31st May 2024

Reserved Matters Application including access, layout, landscaping and scale pursuant to Outline Planning Permission 14/02121/OUT for internal Primary and Secondary Streets along with the part discharge of conditions 12, 16, 17 and 19 for Phase 1B at Himley Village, Bicester

Further to discussions with yourself and Officers at Oxfordshire County Council Highways Department I am submitting a revised scheme pursuant to Reserved Matters application 23/01493/REM for Phase 1B, Himley Village, Bicester.

TITLE  
**S278 OFFSITE HIGHWAY WORKS  
 PRIMARY ACCESS JUNCTION  
 GENERAL ARRANGEMENT  
 SHEET 1**

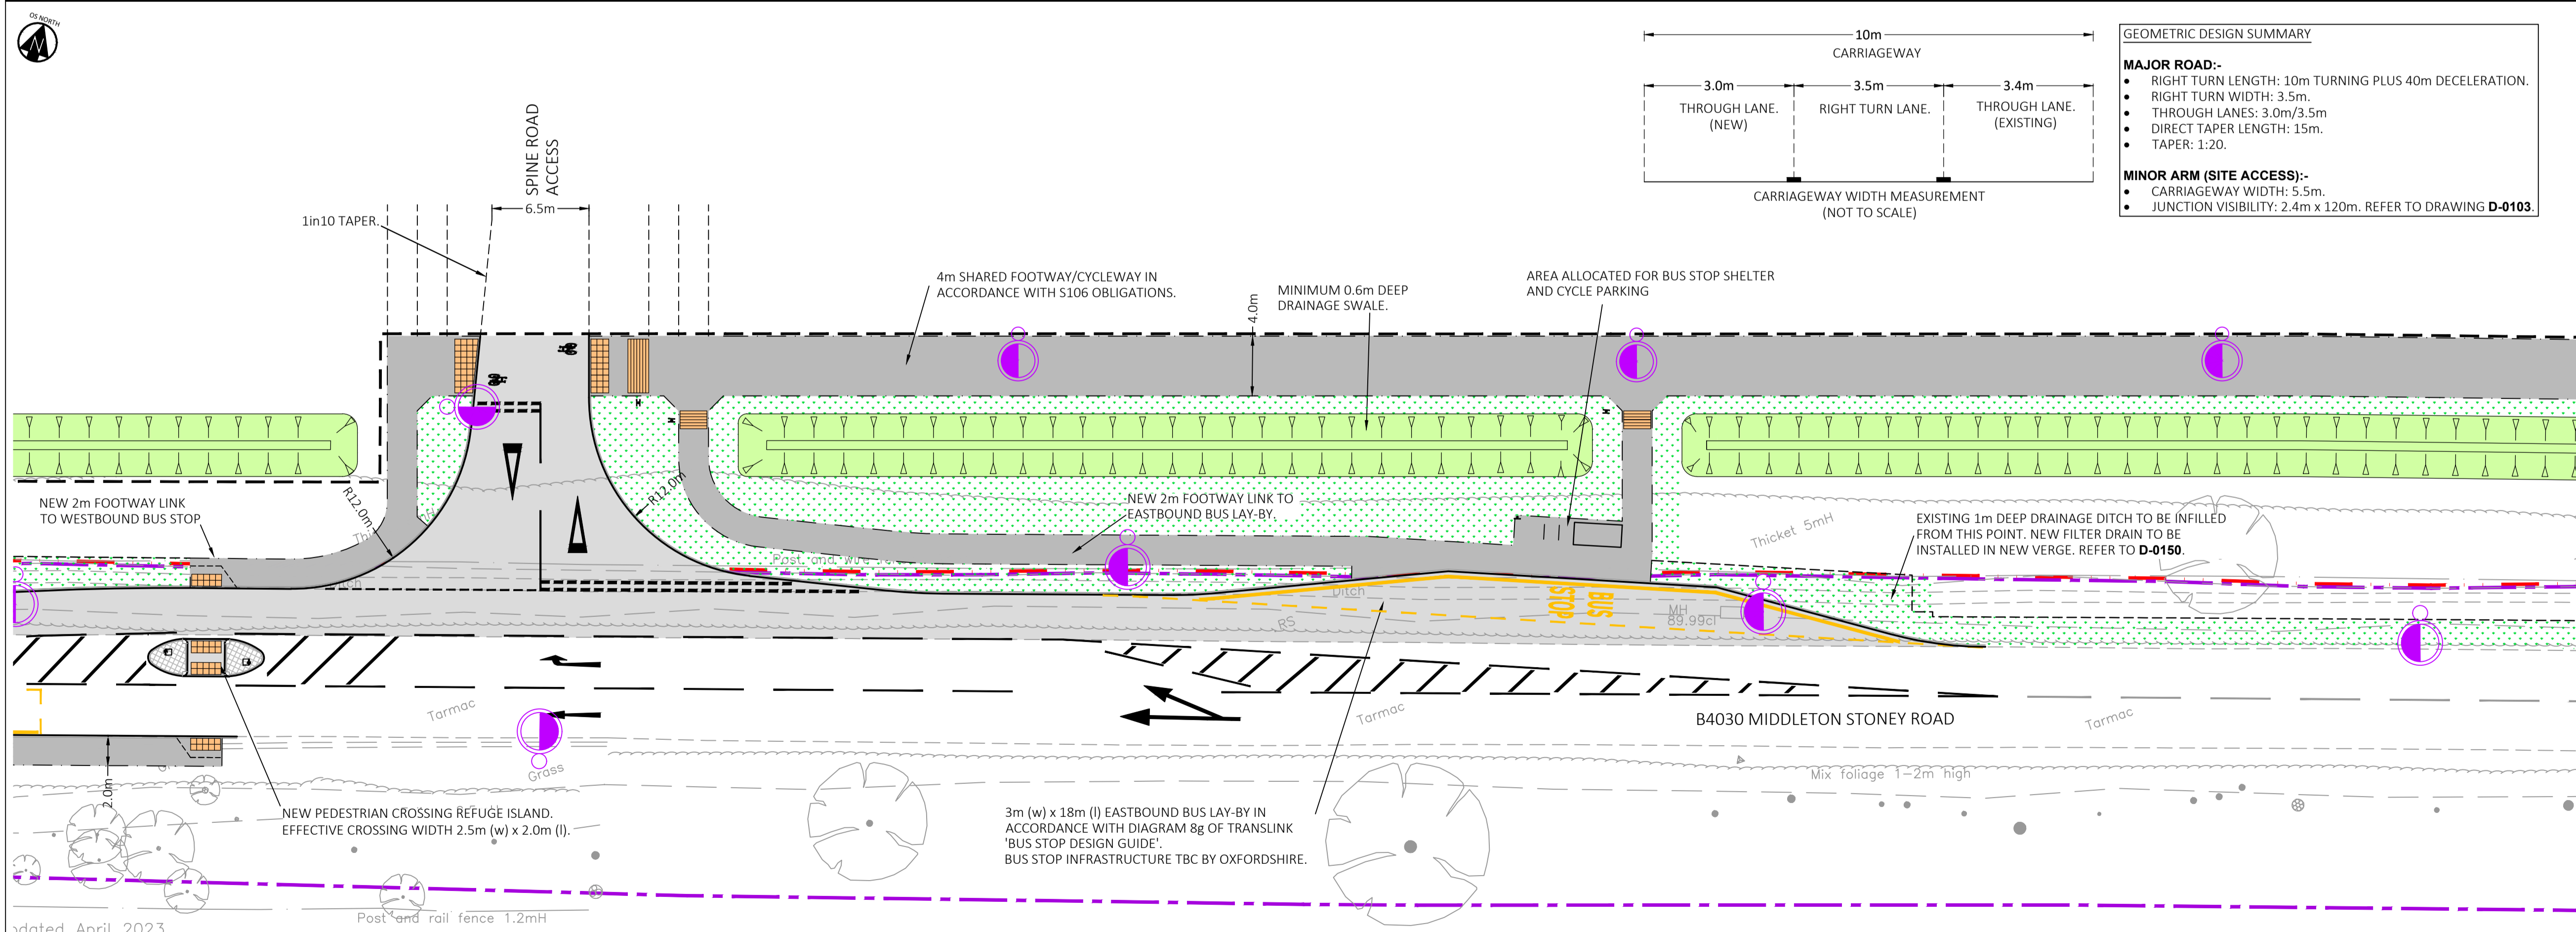
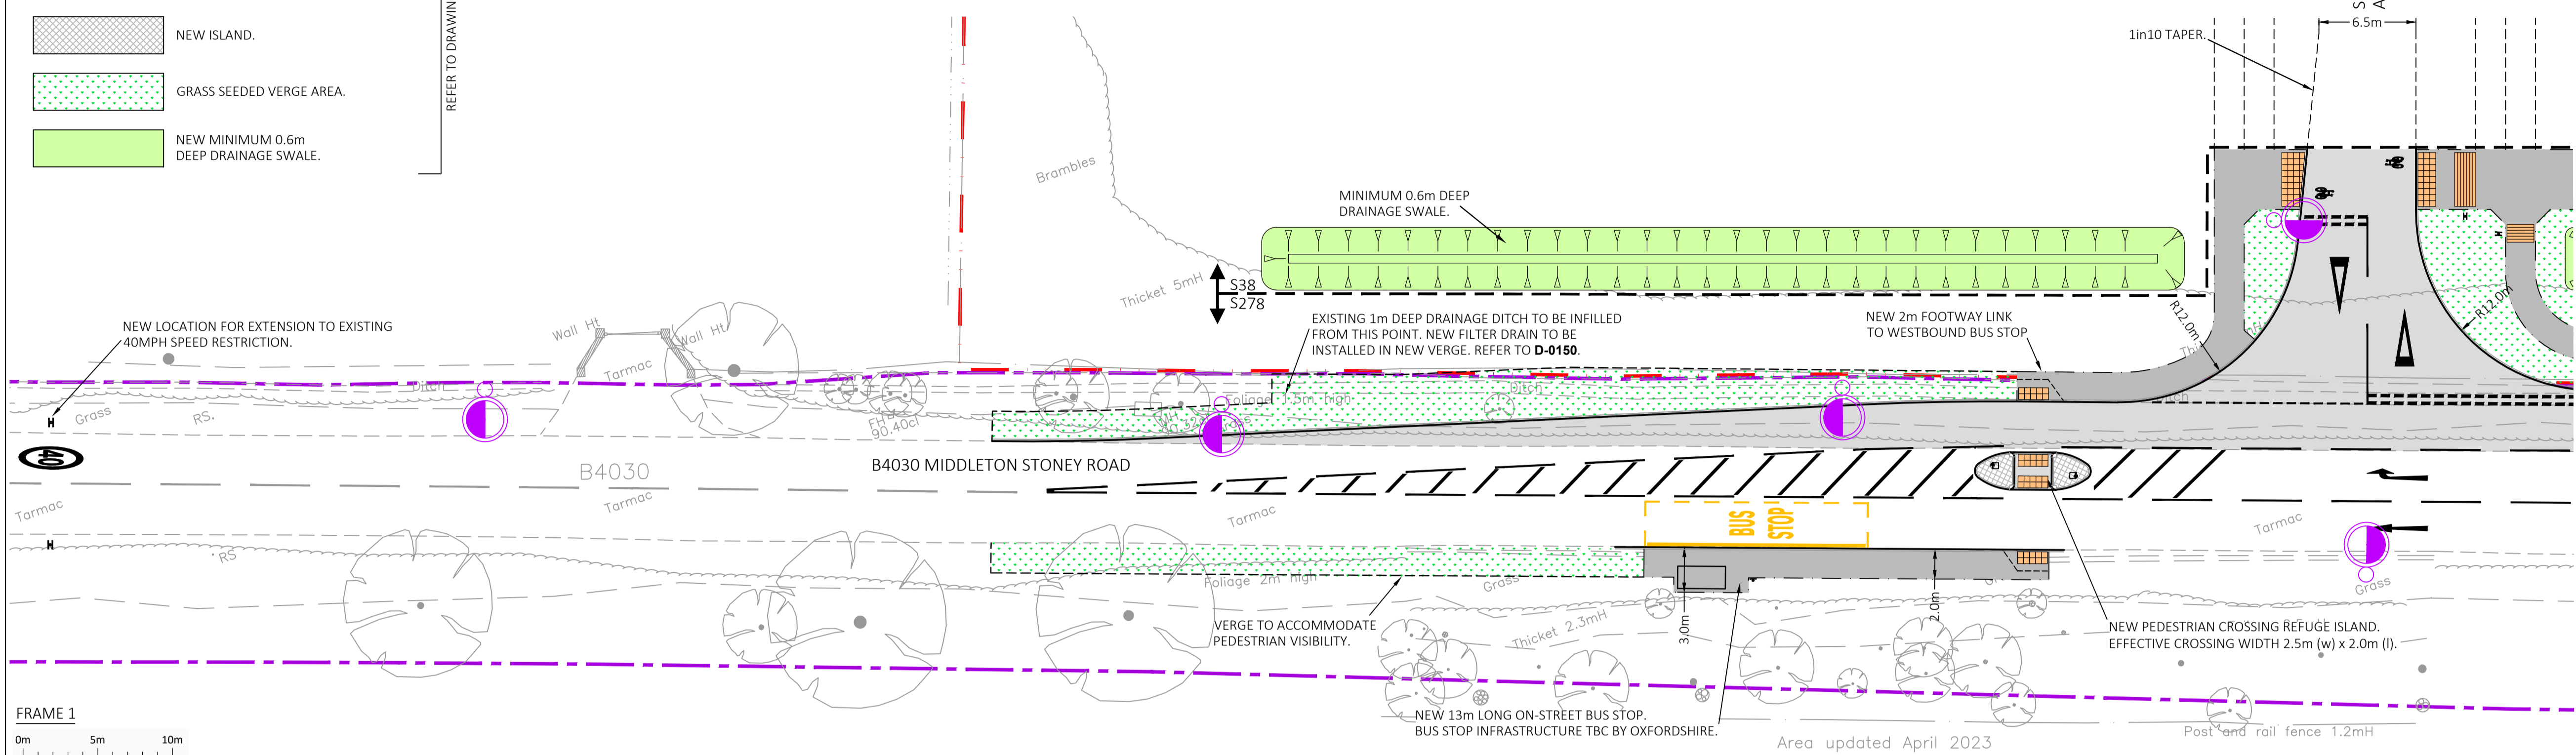
“ATE suggested a segregated walking and cycling route along B4030 Middleton Stoney Road would significantly increase the legibility, safety and therefore attractiveness for those considering whether to walk, wheel and cycle, in line with Figure 4.1 of LTN 1/20. It appears as though a shared use facility has been retained; however the following improvements have been made.

The above improvements are welcomed and supported, however it is felt the access to the Primary Spine Road would also benefit from the same priority arrangement proposed at the Secondary Street access. This would assist those joining infrastructure within the proposal site as well as future proofing connections to the west.

A cycle priority crossing has been added across the Primary Access Road to be consistent with the cycle priority crossing already proposed across the Secondary Access Road.

TITLE  
**S278 OFFSITE HIGHWAY WORKS  
PEDESTRIAN/CYCLE LINK  
GENERAL ARRANGEMENT  
SHEET 3**

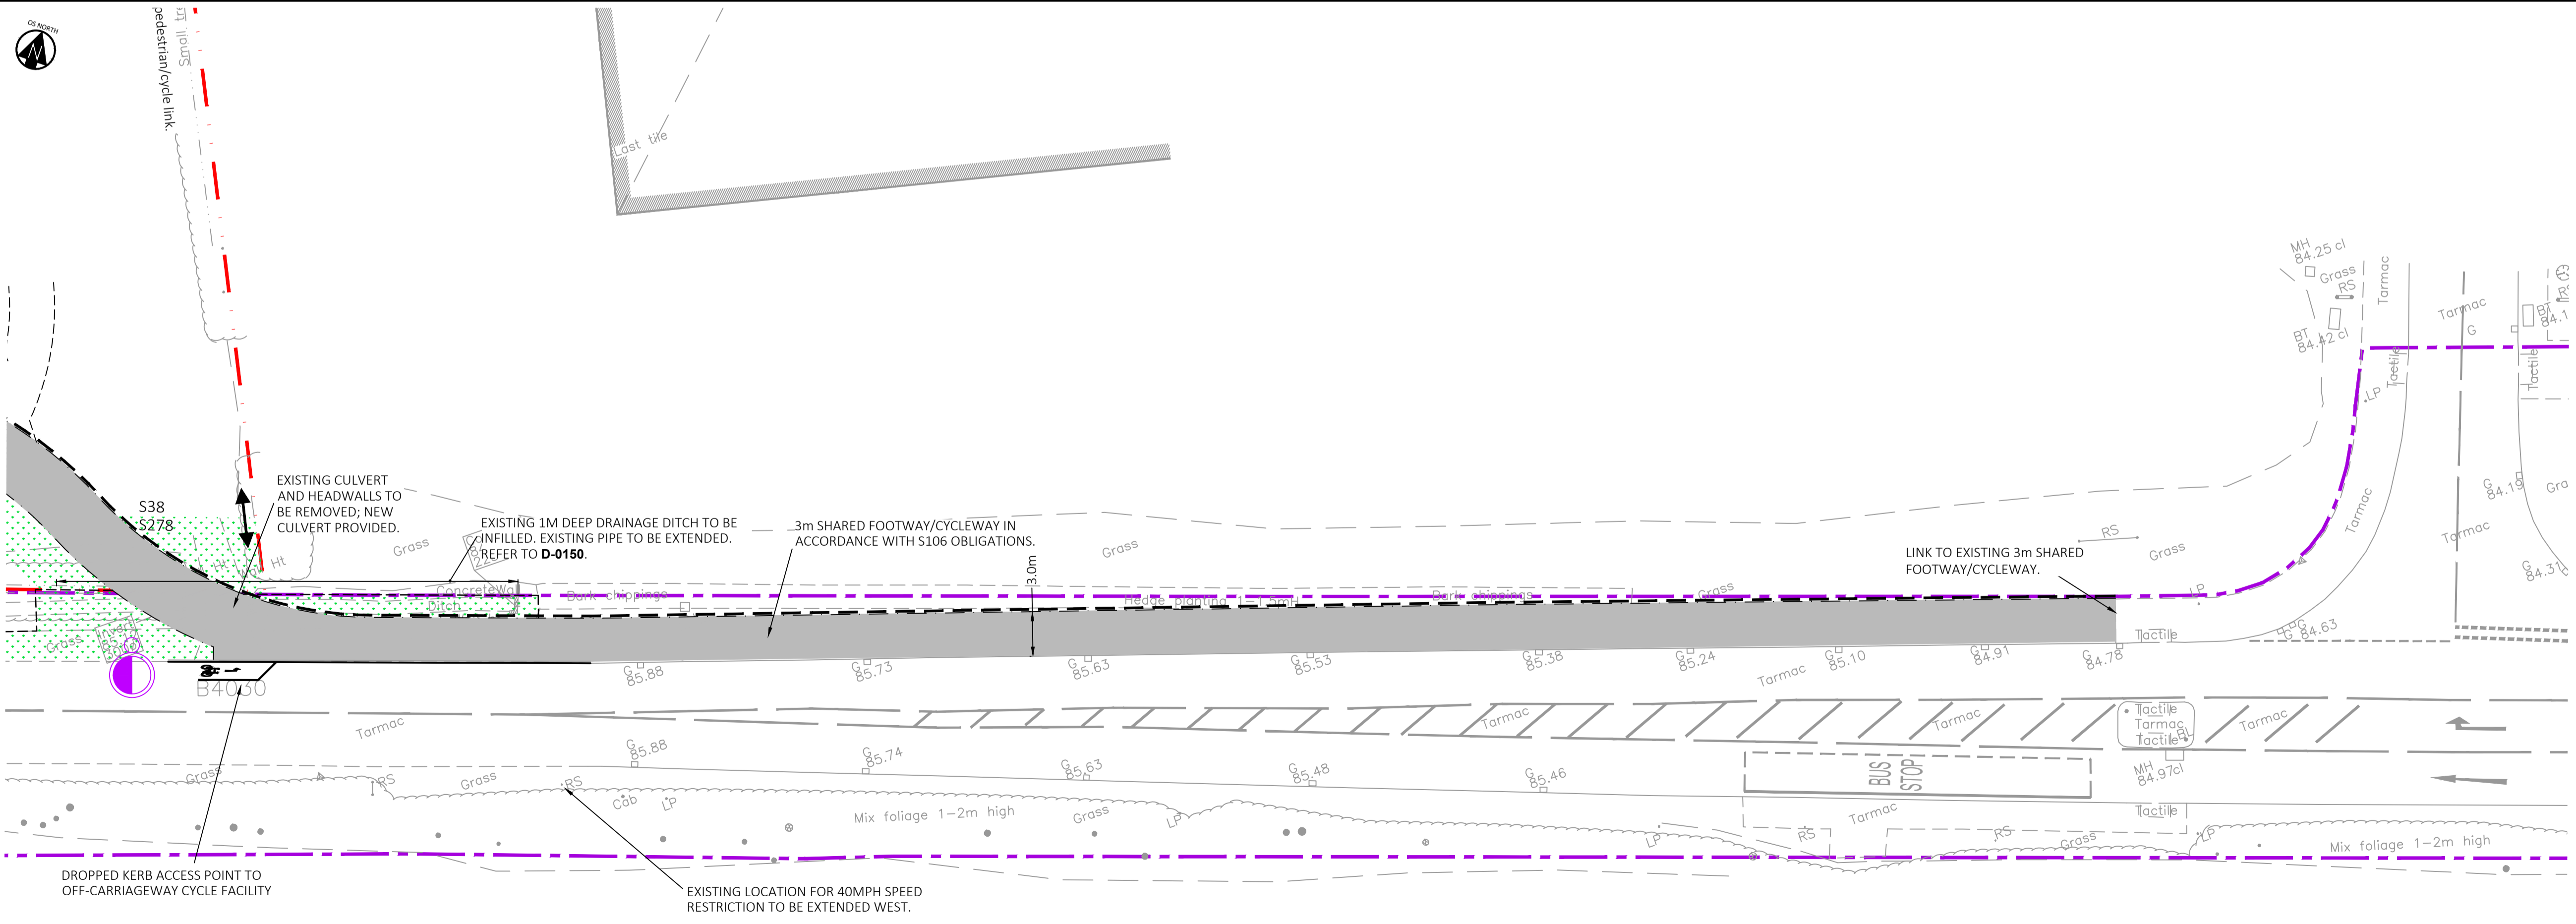
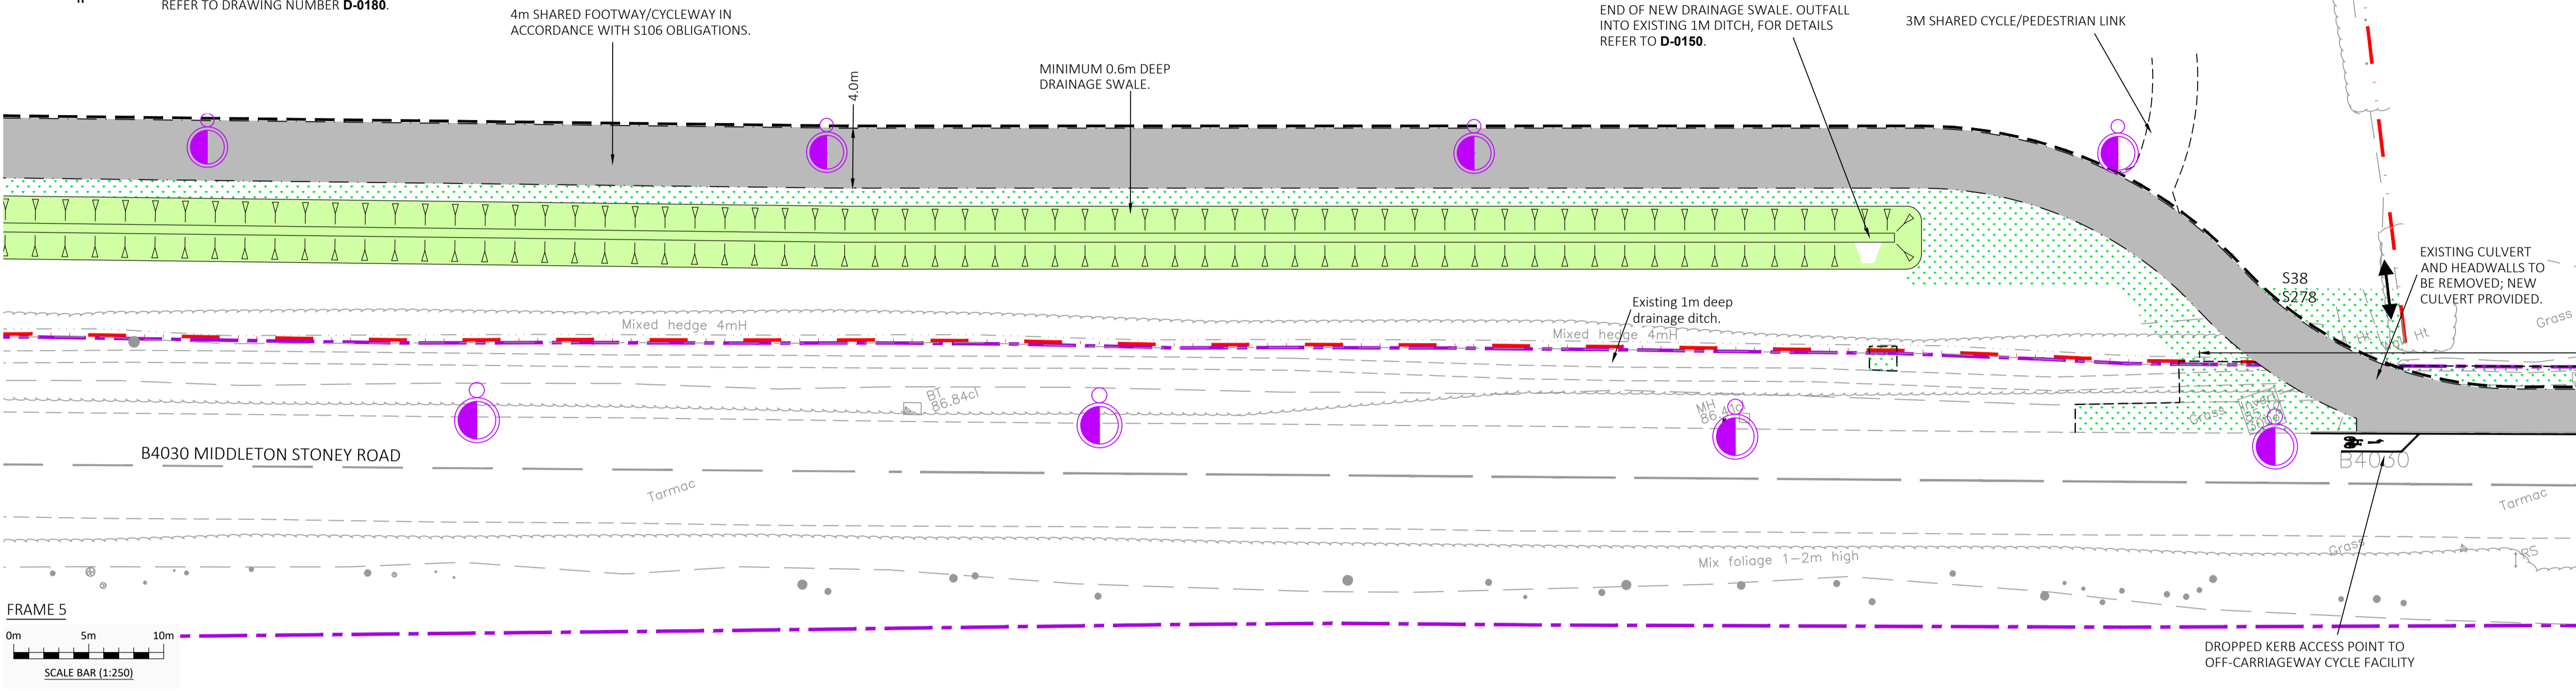
“Access to the site requires a minimum of 1 metre horizontal buffers from the motor vehicle carriageway in accordance with LTN 1/20 Table 6.1 and OCC’s own Cycle Design Standards (3.2.7) and ideally also segregation between pedestrians and cycles.”

To the east of the 'lazy S' bend it is still unclear whether a buffer is to be included between the shared use path and highway."

We believe this comment relates to the connection to the existing off site 3 metre wide shared footway / cycleway at Empire Road to the east of the proposed development. Based on Highway Record information, the width of highway land varies between 3 – 4 metres along this section of verge. Therefore, due to the land to the north being out of the control of both Cala Homes and the Local Highway Authority, Cala are unable to provide the 1 metre horizontal buffer to the carriageway. However, the proposed 3 metre wide shared footway / cycleway is consistent with the existing infrastructure that Cala will be connecting into and will provide a valuable connection between the proposed development and the surrounding cycle network.

As per the response to the BBUG comment, based on Highway Record information, the width of the highway land varies between 3 – 4 metres along this section of verge. Therefore, due to the land to the north being out of the control of both Cala Homes and the Local Highway Authority, Cala are unable to provide the 1 metre horizontal buffer to the carriageway. However, the proposed 3 metre wide shared footway / cycleway is consistent with the existing infrastructure that Cala will be connecting into and will provide a valuable connection between the proposed development and the surrounding cycle network.
